***MODIFICATION REQUEST:
Extension of Kareena Private Hospital
86 Kareena Road, Caringbah
MP08_0169 MOD 1***

Extensions to the central hospital building

Director-General's
Environmental Assessment Report
Section 75W of the
Environmental Planning and Assessment Act 1979

May 2013

Proposed Ground Floor Plan

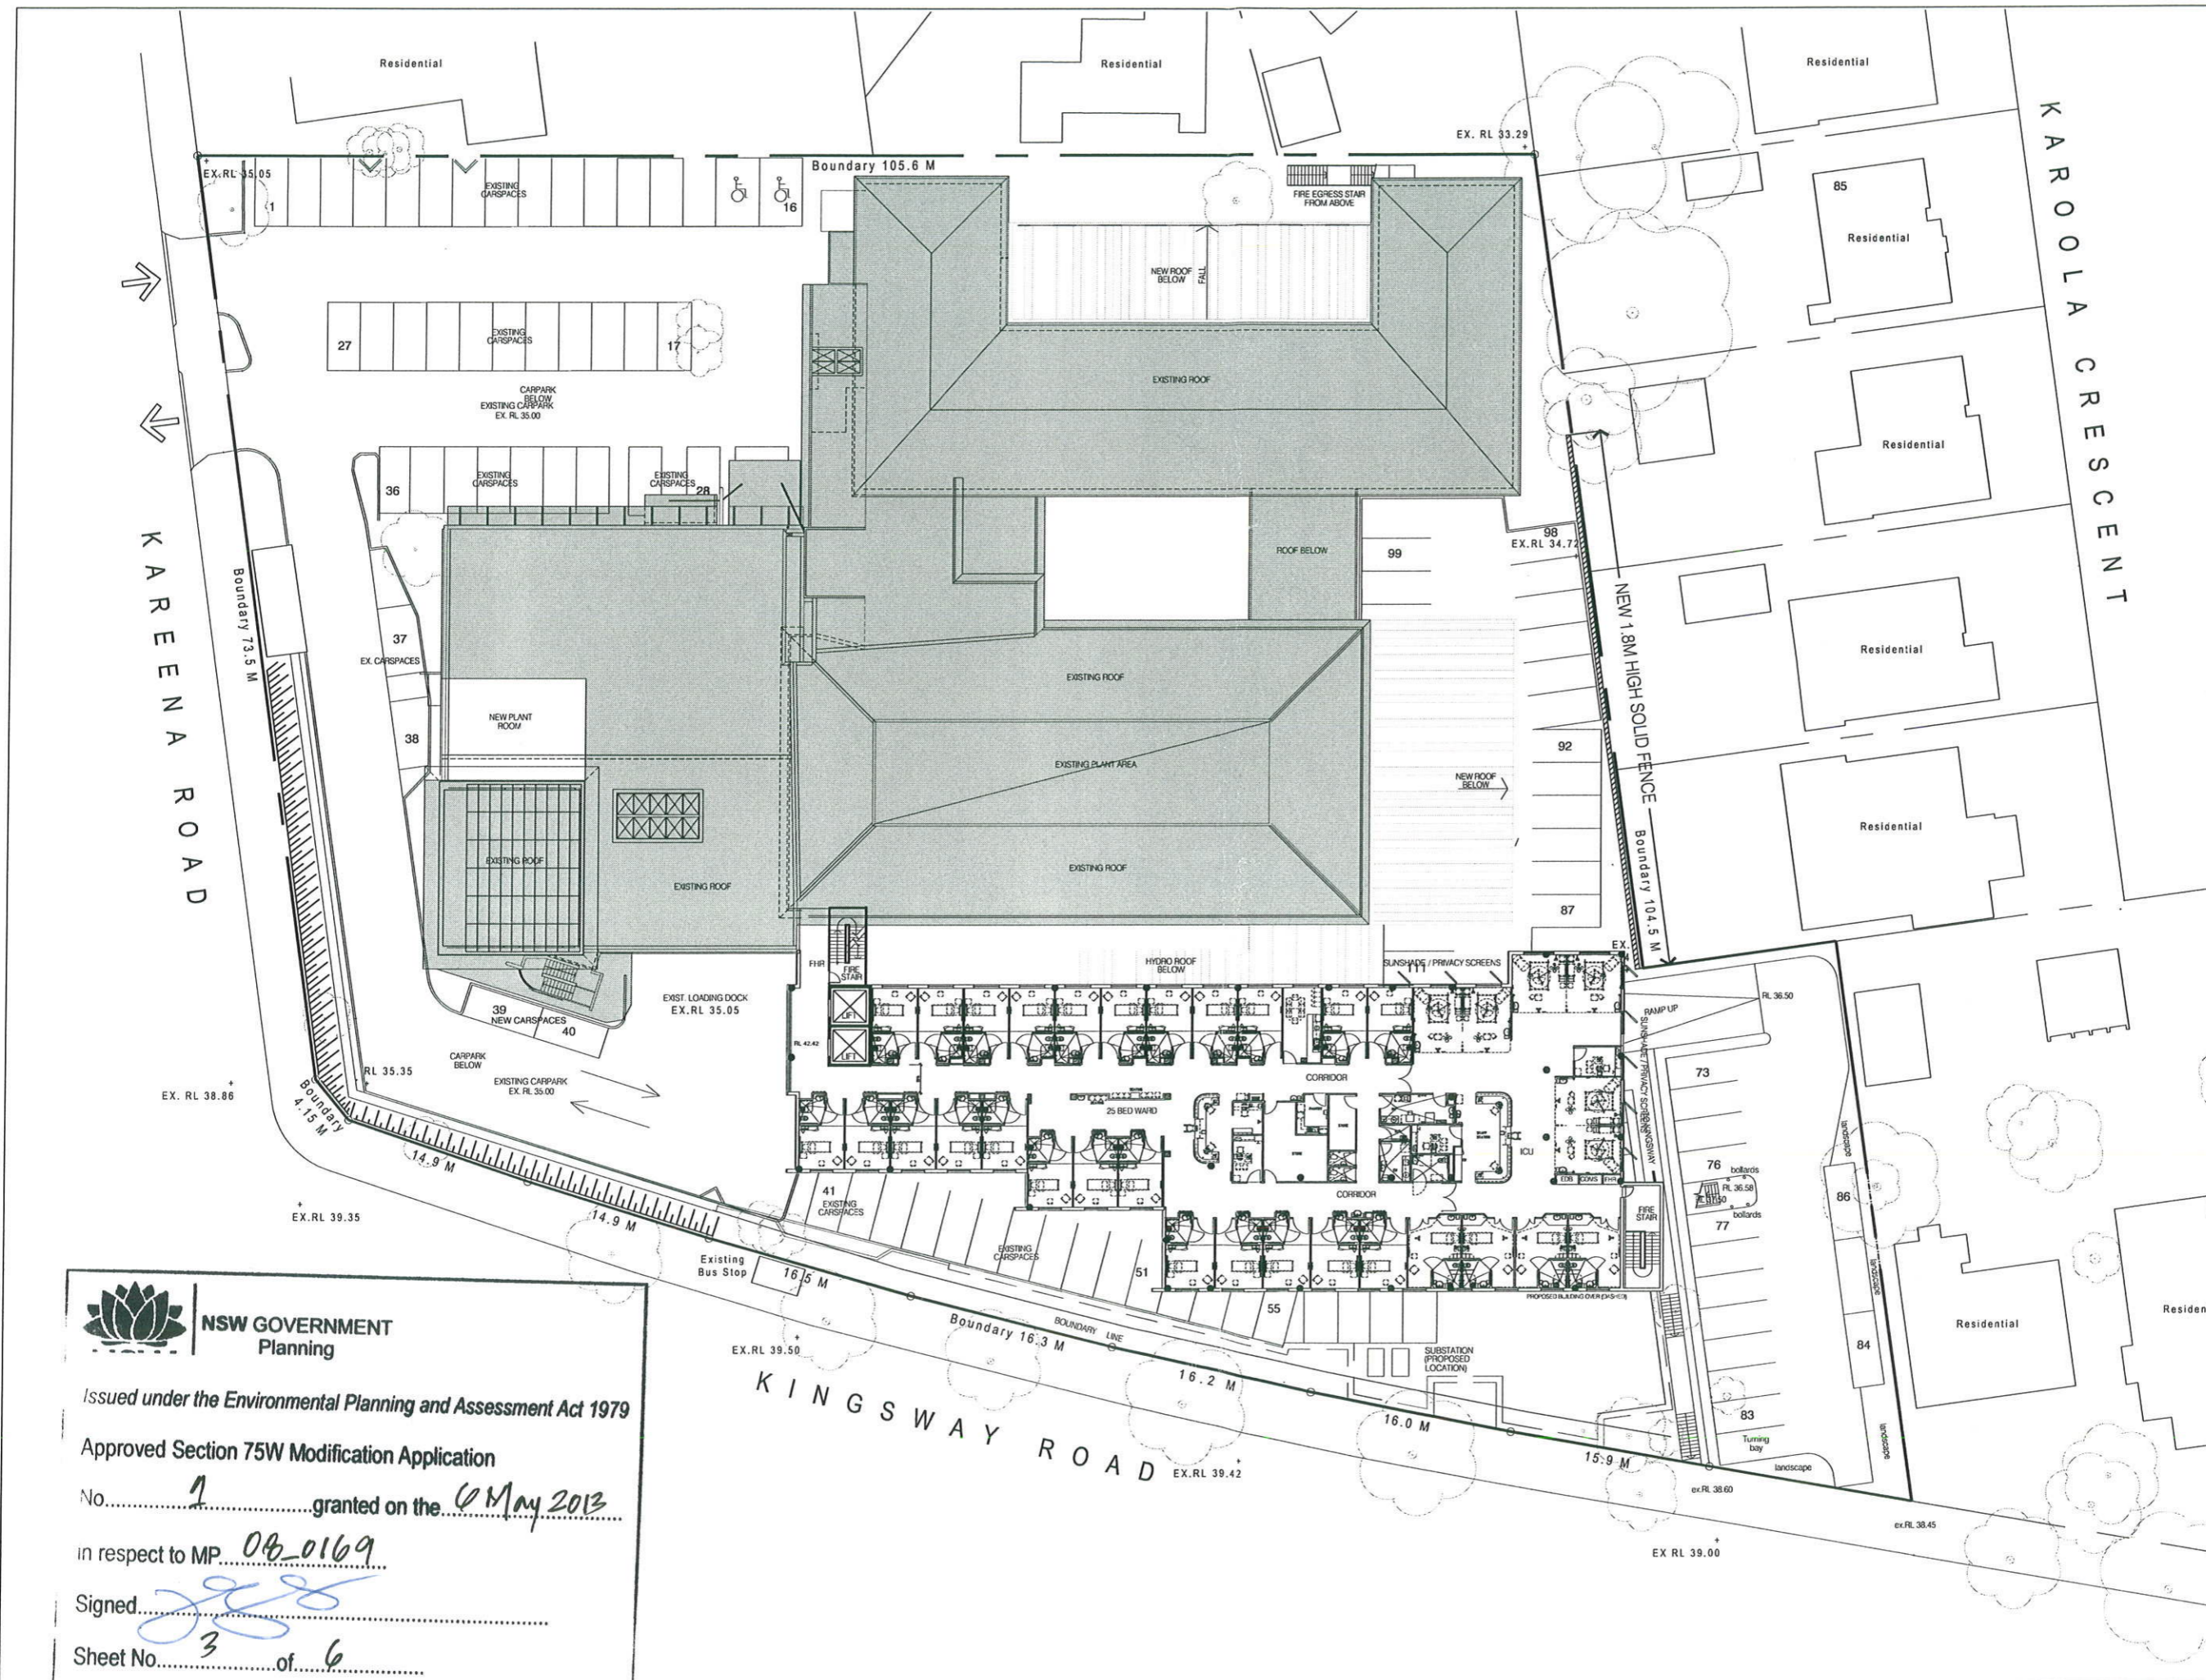
As detailed in **Section 2** of this report, the proposal seeks further extensions to the central hospital building. The plans indicate five new columns are proposed to support the east extension above a portion of the approved onsite carpark. The approximate location of these columns is illustrated in **Figure 6**.

Council raises concern over the placement of these columns as they appear to conflict with the position of parking spaces and vehicle aisles of the approved onsite carpark. This conflict is identified in **Figure 6** above.

The Department acknowledges Council's concern noting that the current positioning of columns would likely conflict with up to 20 of the 127 parking spaces approved on the site. The number of parking spaces was approved partly on the basis that it complied with Council's minimum requirement under their DCP. In this regard, any reduction from the approved number of parking spaces of the scale noted above is unacceptable.

Given the relatively minor increase in size of the proposed extension and the use of lightweight building materials (described in **Section 2**), an alternative structural arrangement of columns that avoids conflict with the onsite carpark is achievable and will allow the approved carparking arrangements to be met.

The Department therefore considers it appropriate to impose a new condition in the approval to ensure the abovementioned requirement is met and approved by the certifying authority prior to issue of the Construction Certificate.

ELEVATION - EAST

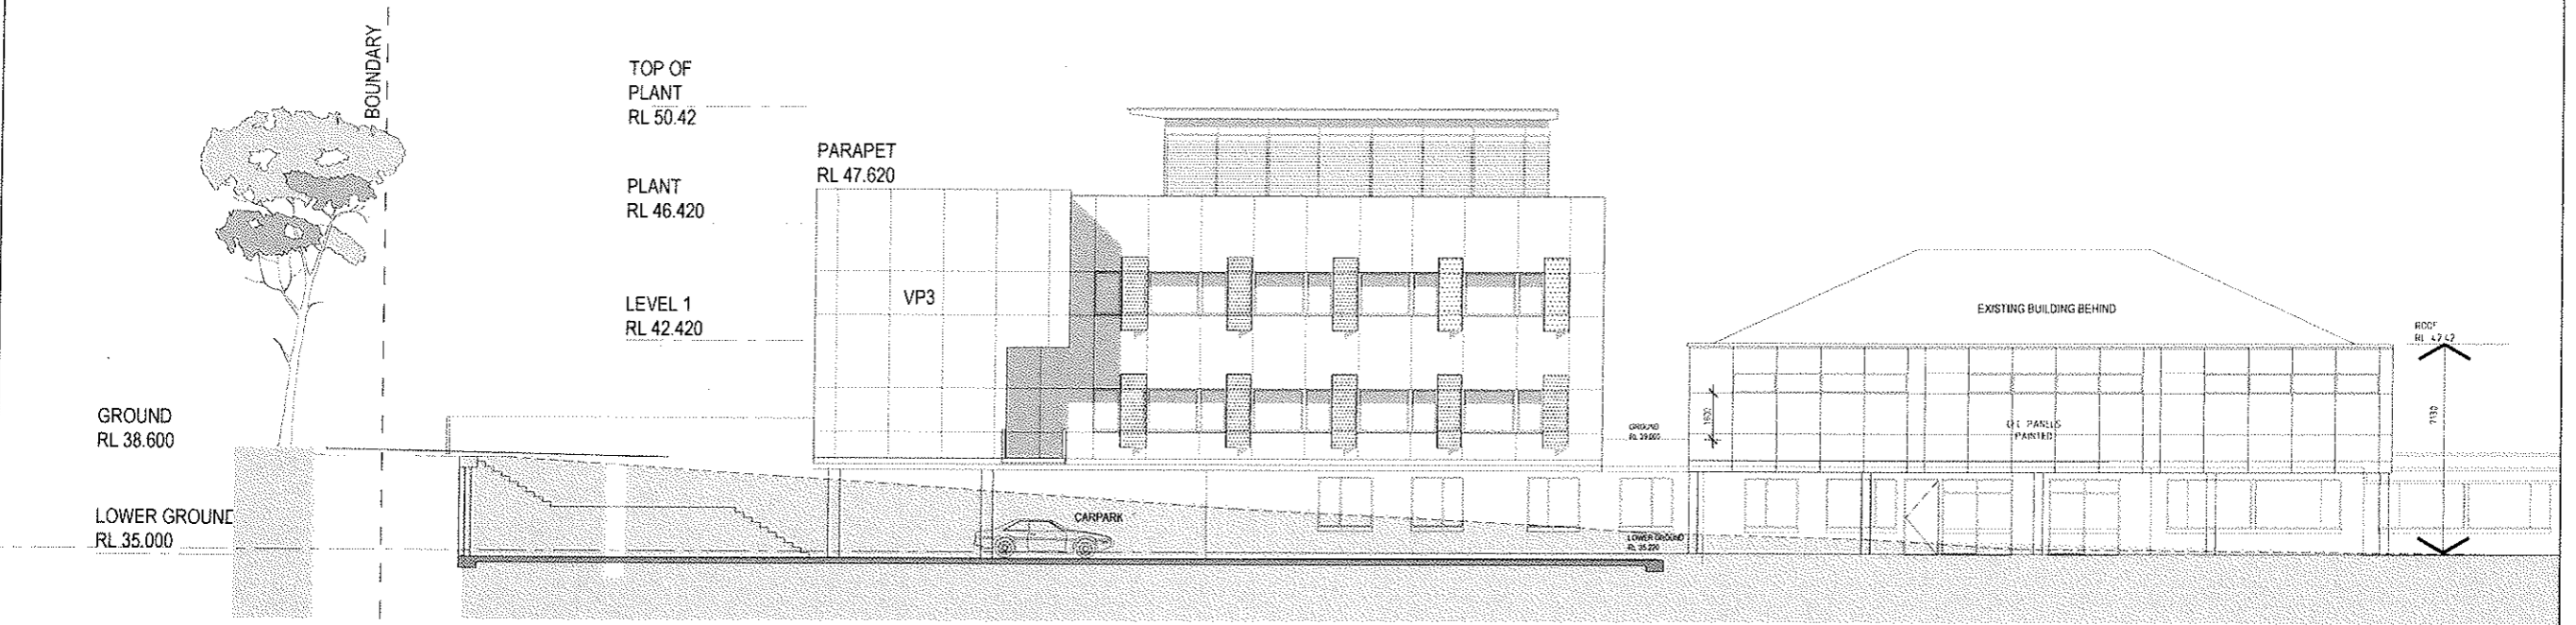
Council noted in its submission that given the reduced proximity of windows of the proposed east extension to the rear yards of adjoining residential properties, the privacy of these properties could be compromised. The location of windows to the proposed east extension in relation to adjoining residential properties is shown in **Figure 5**.

In order to minimise privacy impacts, Council recommends the consideration of a number of window treatments including the use of highlight windows, opaque glazing or external louvres set at an angle/direction to direct view lines away from residential properties.

Despite the elevation and proximity of the extension to the boundary of the affected residential properties, the Department notes that the proposal adequately addresses privacy impacts by incorporating highlight windows with sill heights measuring 1.6m above the finished floor level and would prevent overlooking into the adjoining residential properties.
